Front and rear single storey extensions and dormers to front and rear roof slopes.

32 Mill Lane Rustington

Thank you for your internet representation made on 5th February 2019 which has been recorded as '**an objection**' with the comments as follows:

PROPOSED ROOF PLAN
1:100

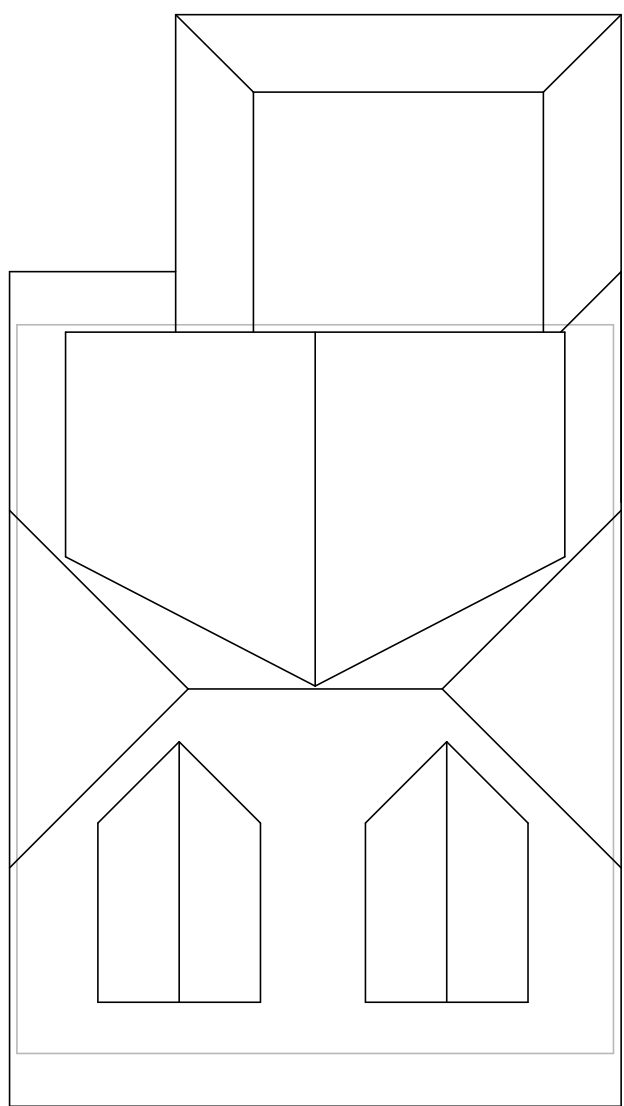
However, the inclusion of dormer windows on the rear elevation is inappropriate. At present, and since our property was built over 50 years ago, our garden has not been overlooked. The two dormer windows would destroy the privacy we currently enjoy.

PROPOSED REAR ELEVATION
1:100

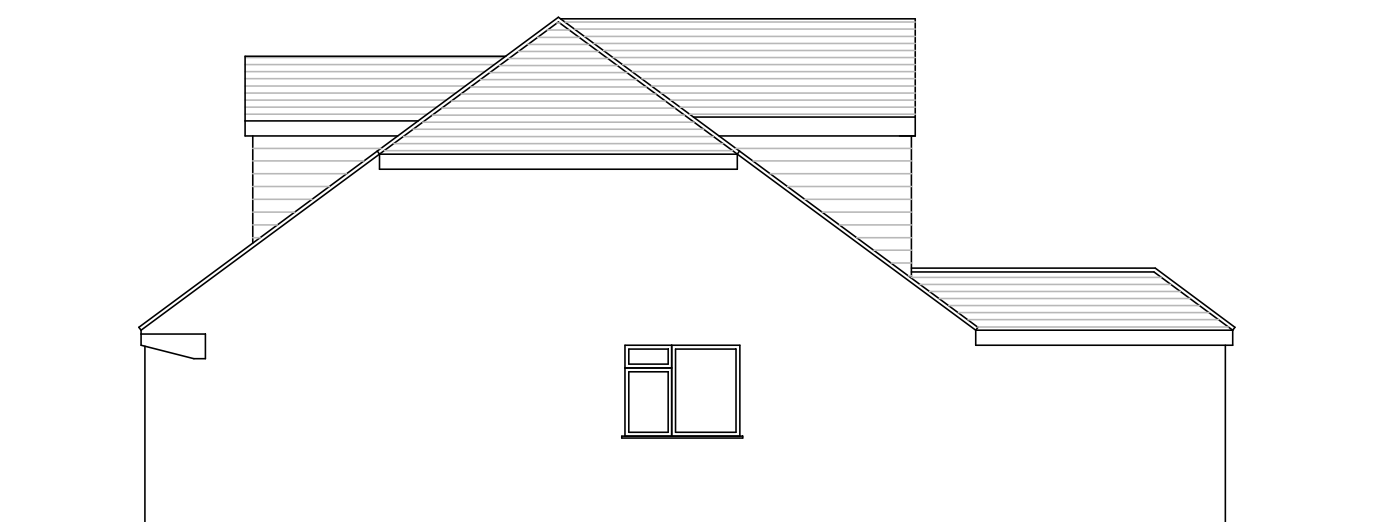
Whilst it could be argued there are other two story properties near this location, they are some way off and therefore do not impact on our privacy
